App no: 23.0138

Address: Twin Brook Farm Up Brooks Clitheroe

Proposal: Construction of a pair of semi-detached dwellings as a change of house type to the single large detached dwelling on Plot 1 previously approved on application 3/2019/1103

Site Plan
Scale: 1:500@A1

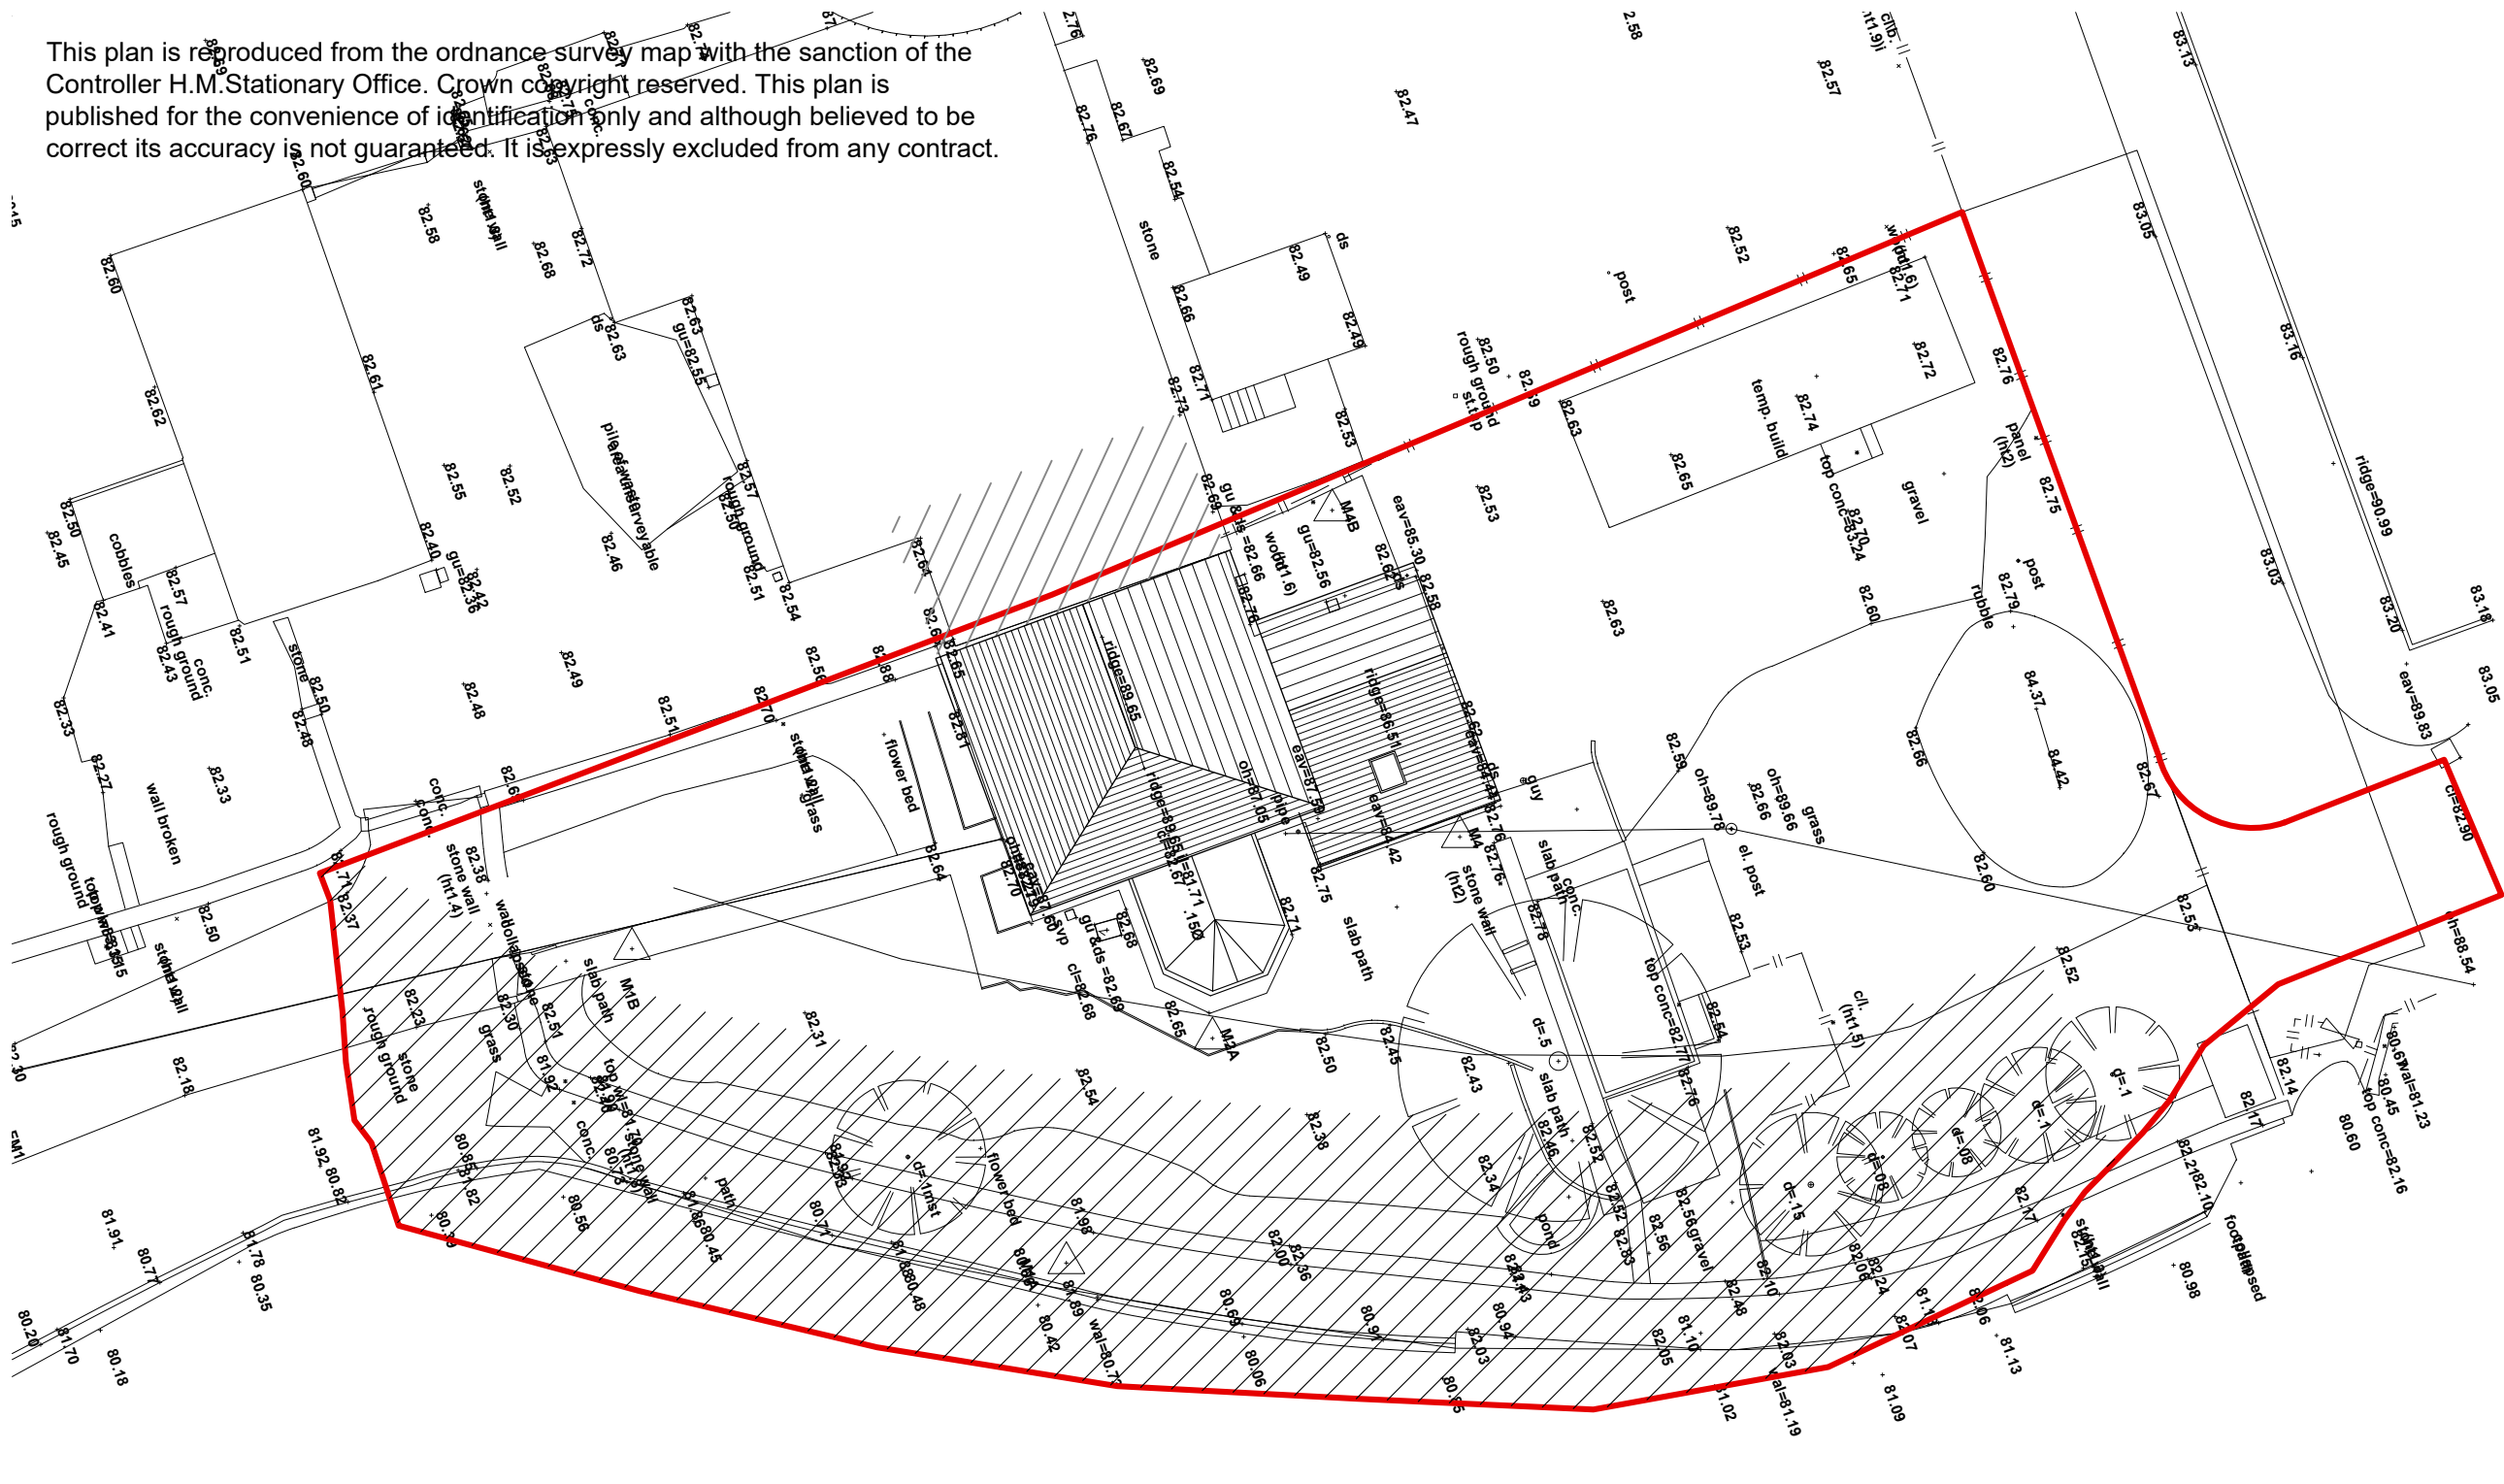
The 2 x 3 bedroom dwellings would require 2 parking spaces each together with electric vehicle charging and secure, covered cycle stores.

There are 3 spaces shown for each dwelling which could be reduced however we would raise no objection to the small overprovision.

We would not support any informal parking which may obstruct the public footpath 301006a which runs past the site.

2. Prior to the occupation of each dwelling the parking and turning areas shall be constructed in a bound porous material and made available for use and maintained for that purpose for as long as the development is occupied.

3. Prior to first occupation each dwelling shall have a secure cycle store for at a ratio of 1 cycle space per bedroom.
